Our ref: DOC26/169329-6

2 April 2026

### **EPA Advice on Submissions Report – Kurnell Refinery MOD 7 Infrastructure Consolidation and Remediation – SSD-5544-Mod-7**

Copyright: Copyright in material relating to the base layers (contextual information) on this page is licensed under a Creative Commons Attribution 4.0 Australia licence © Department of Customer Service 2020, (Digital Cadastral Database and/or Digital Topographic Database).

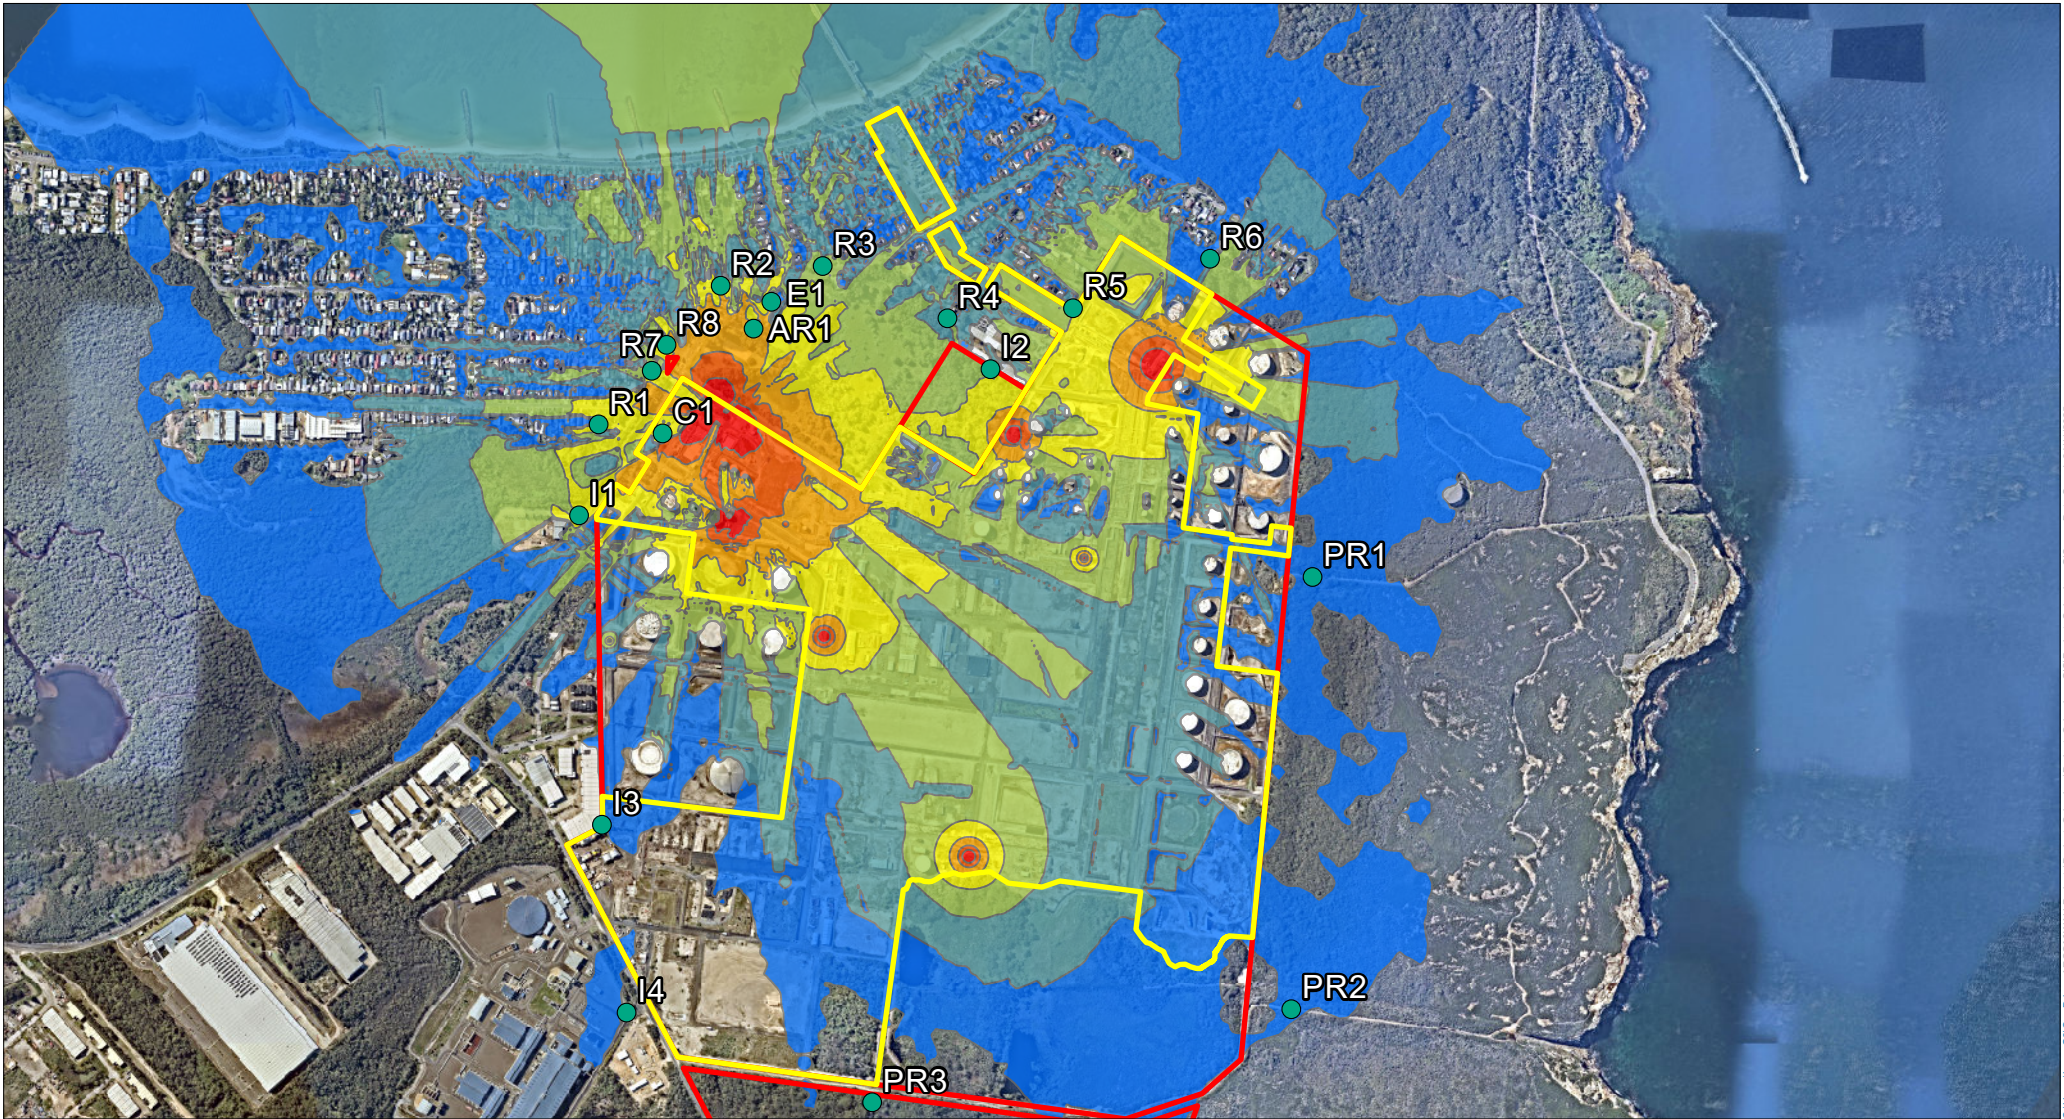
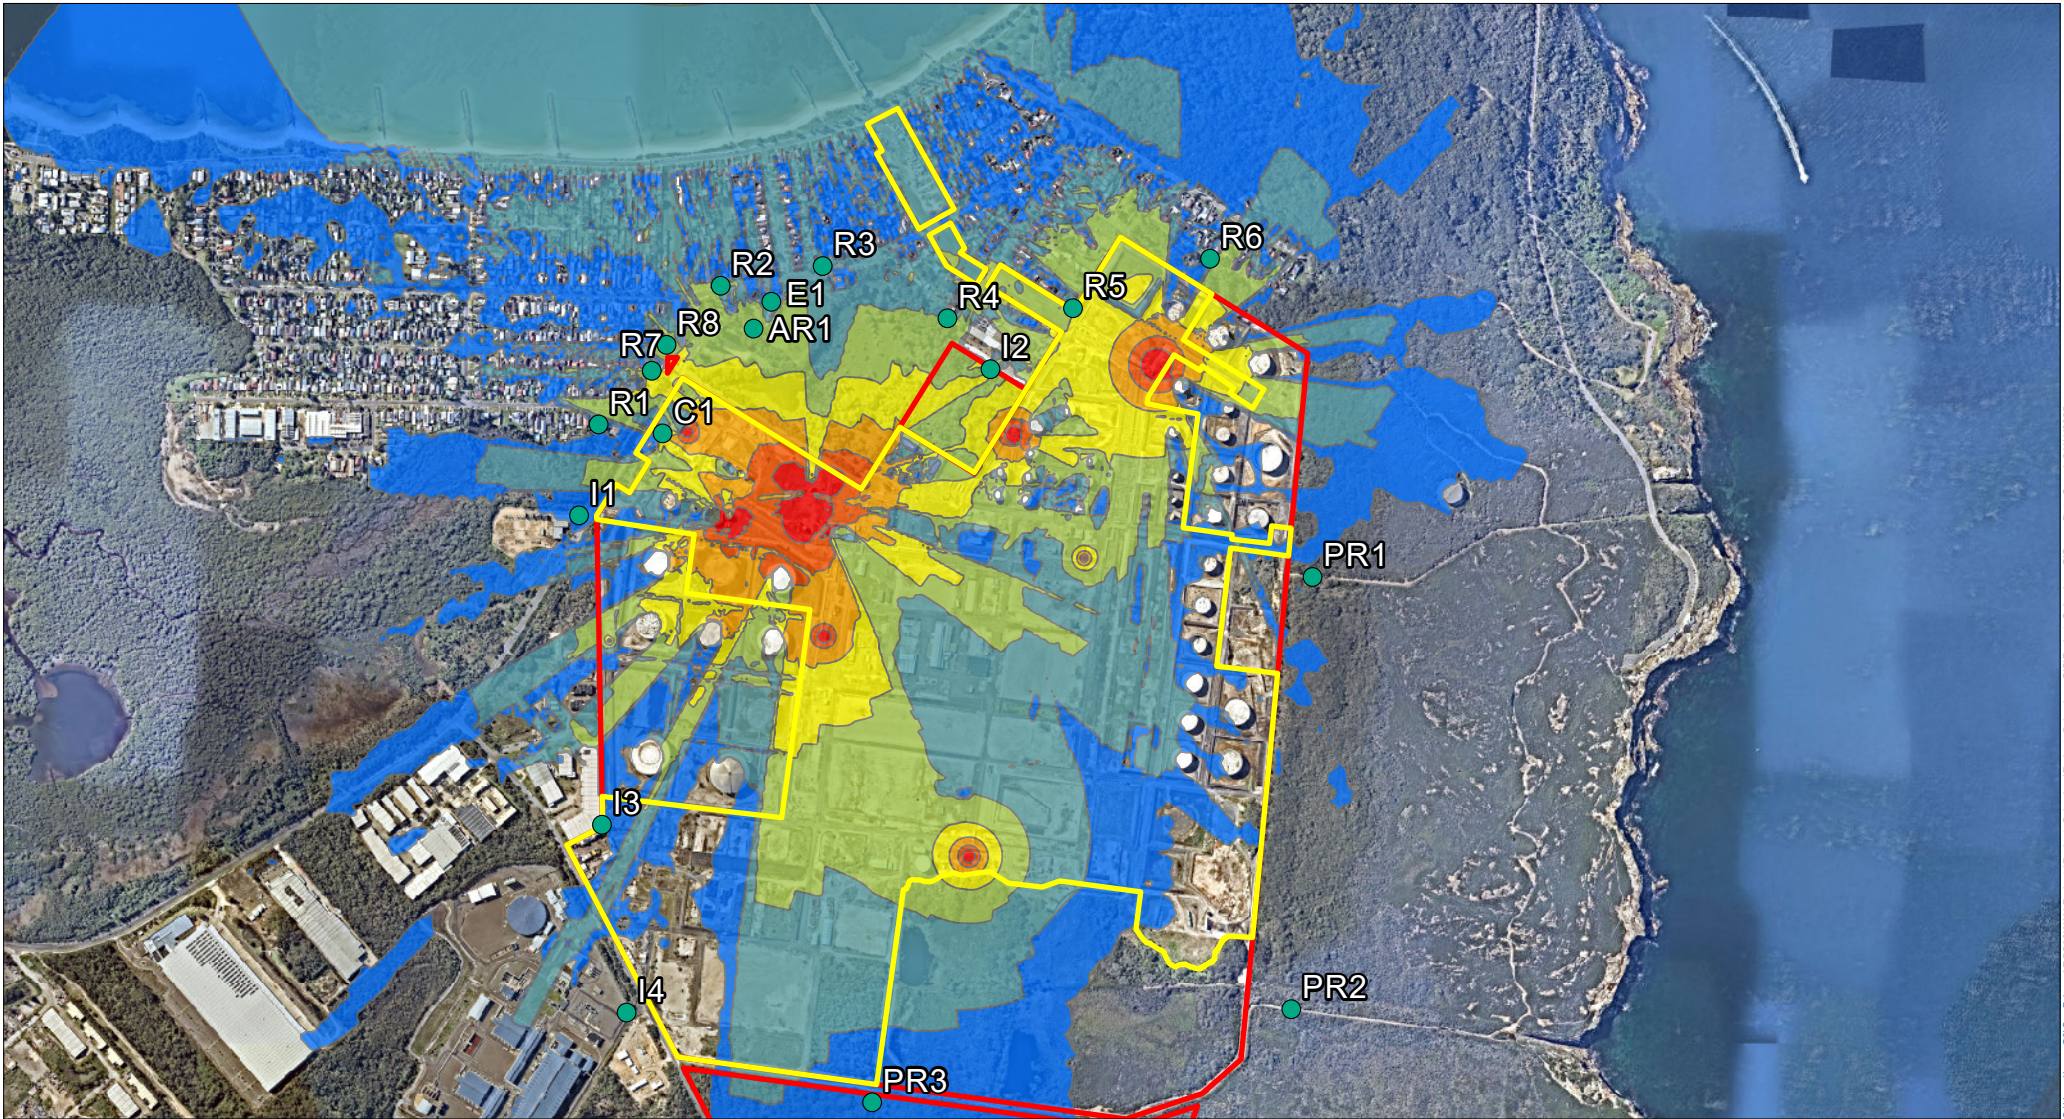
The updated noise contour maps provided in the Updated Noise & Vibration Impact Assessment (UNVIA) indicate that the selected receiver locations (Receivers R1 to R6) may not be representative of the predicted impacts at the surrounding residences. For example, the first contour map in Appendix B of the UNVIA, receivers R5 and R6 appear to have been selected to represent the residences in and around Sharn Street, Captain Cook Drive, Reserve Road and Polo Street. The predicted noise levels for R5 and R6 during normal operations under noise enhancing meteorological conditions are Leq,15min 50 and 36 dBA respectively. However, the noise contour map indicates that receivers surrounding R6 may receive a substantially higher noise level than is reported in Table 5-2, given they appear to be in the 45-49 dBA contour band.

Where a select number of receivers are used to represent a larger area of sensitive receivers, the location should be carefully chosen to be representative of predicted impacts. The information provided in the UNVIA indicates that the currently selected receivers may not be representative of impacts across the surrounding sensitive receivers, and alternative and additional locations may be required.

The EPA recommends that DPHI consider requesting the Applicant review the receivers used to represent impacts at surrounding sensitive receivers to ensure that they are representative of potential impacts and amend the assessment accordingly.

Operational Noise - Daytime Monthly FWS Testing Option 1 - Noise enhancing weather conditions
 Noise contours are shown 1.5 meters above ground level

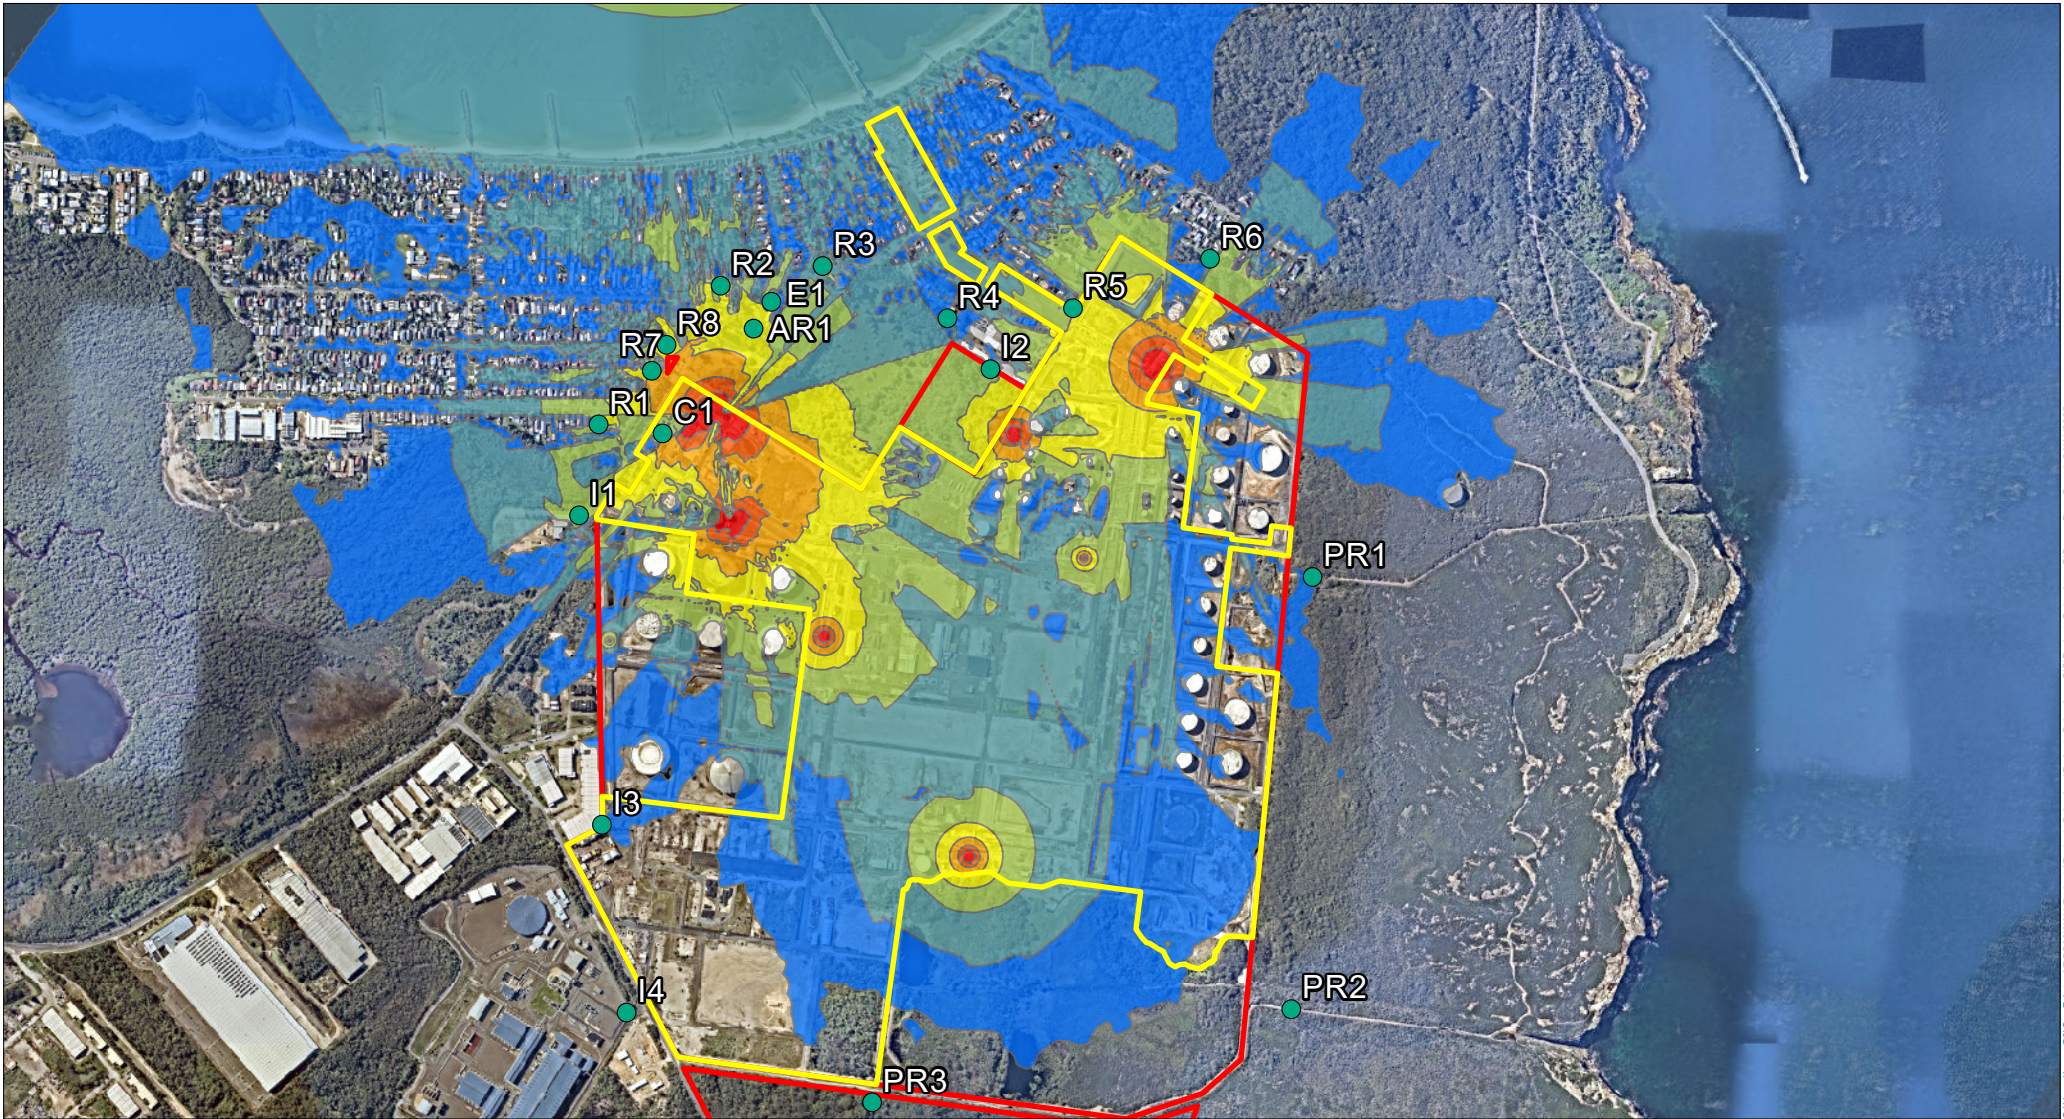
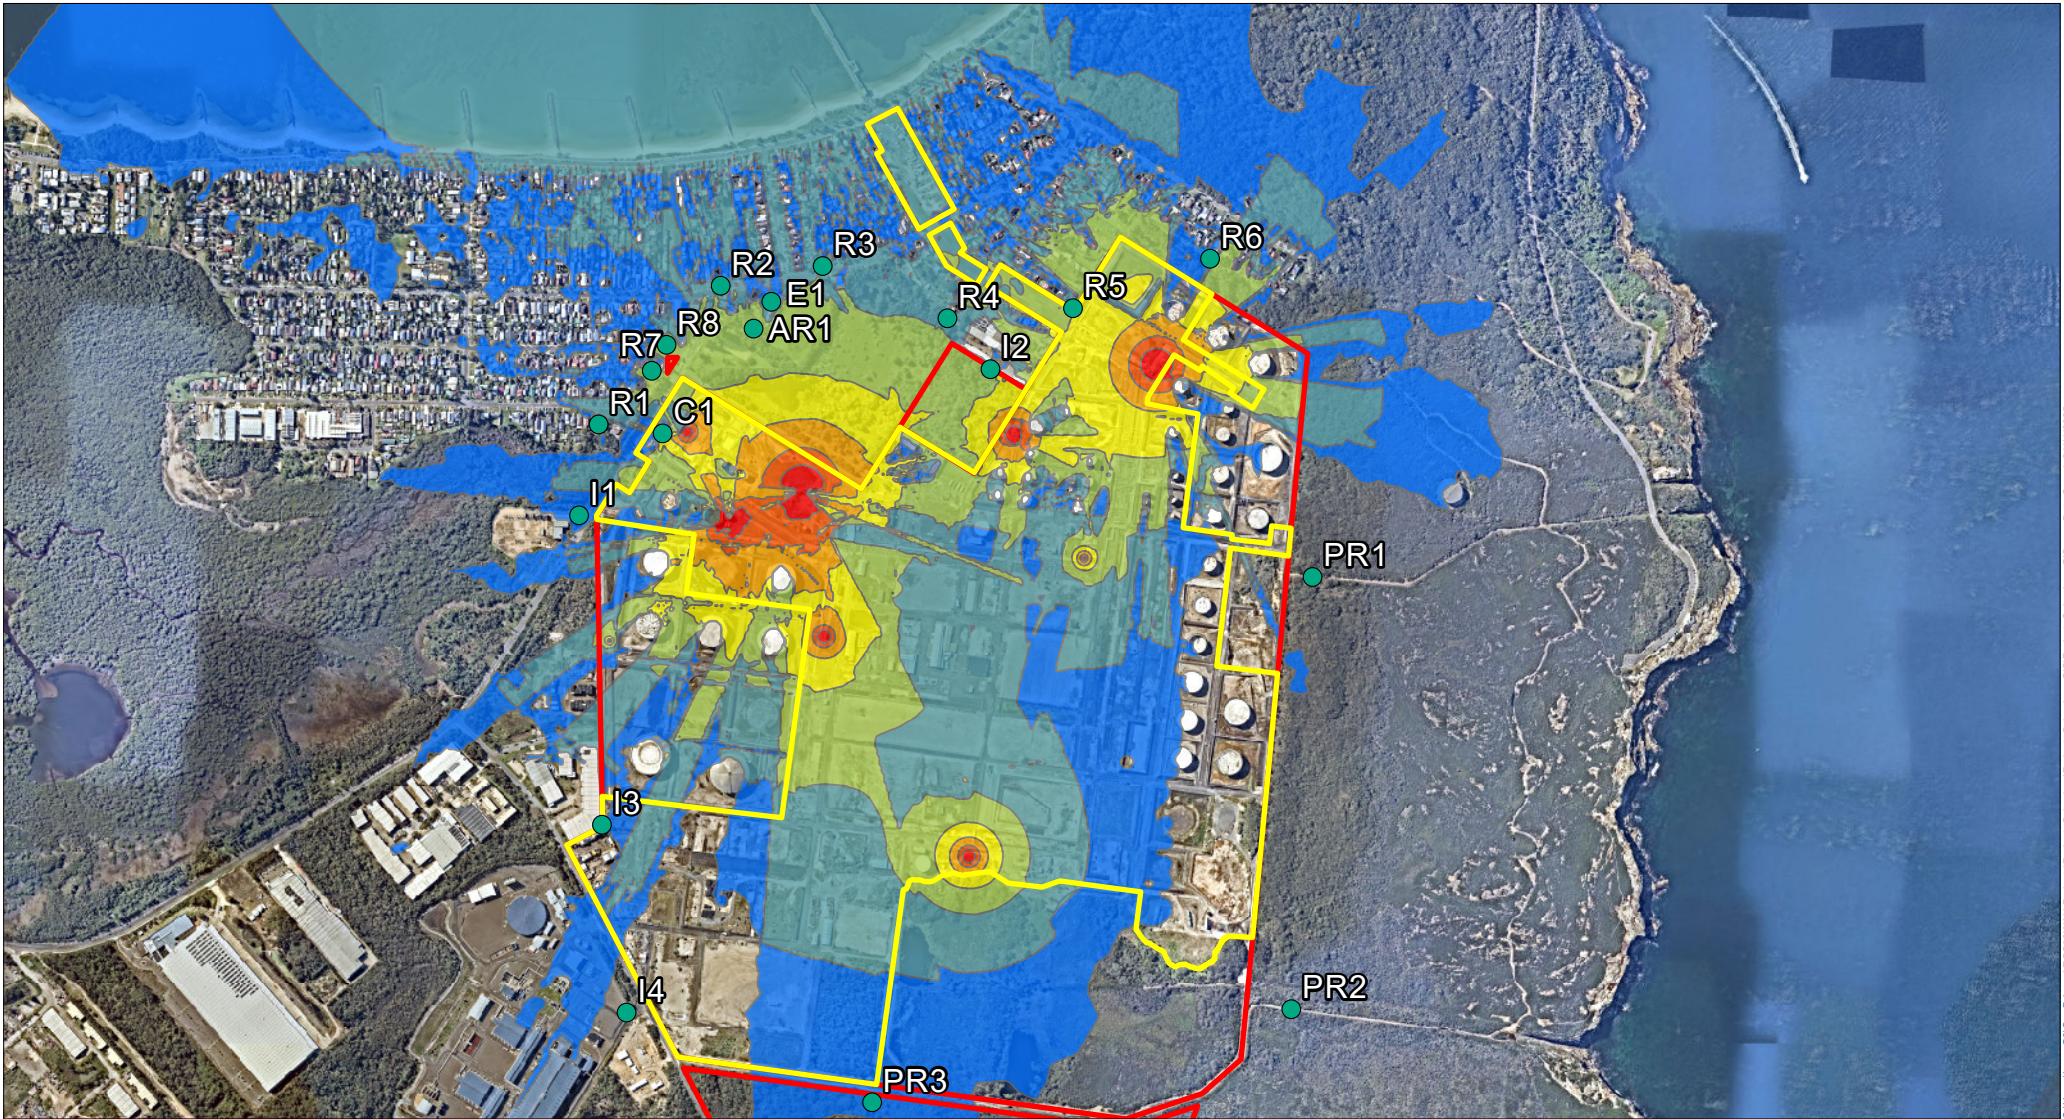
The assessment of the 2 options for the firewater system (FWS) locations in Chapter 5 of the UNVIA indicates that there is a substantial difference in noise emissions depending on which option is chosen, with Option 2 having predicted noise levels more than 10 dB lower than Option 1.

However, in Table 5-7 it appears that the adoption of Option 2 was disregarded solely on the basis of “*site constraints other than noise.*” This is not a sufficient level of information to demonstrate why this option was disregarded as a mitigation option, particularly since noise levels are more than 10 dB lower for Option 2.

- Appropriate assessment of mitigation consistent with the NPfl.
- Transparent reporting and robust assessment of why an option has not been adopted.
- Consideration of alternative or additional mitigation measures as appropriate.
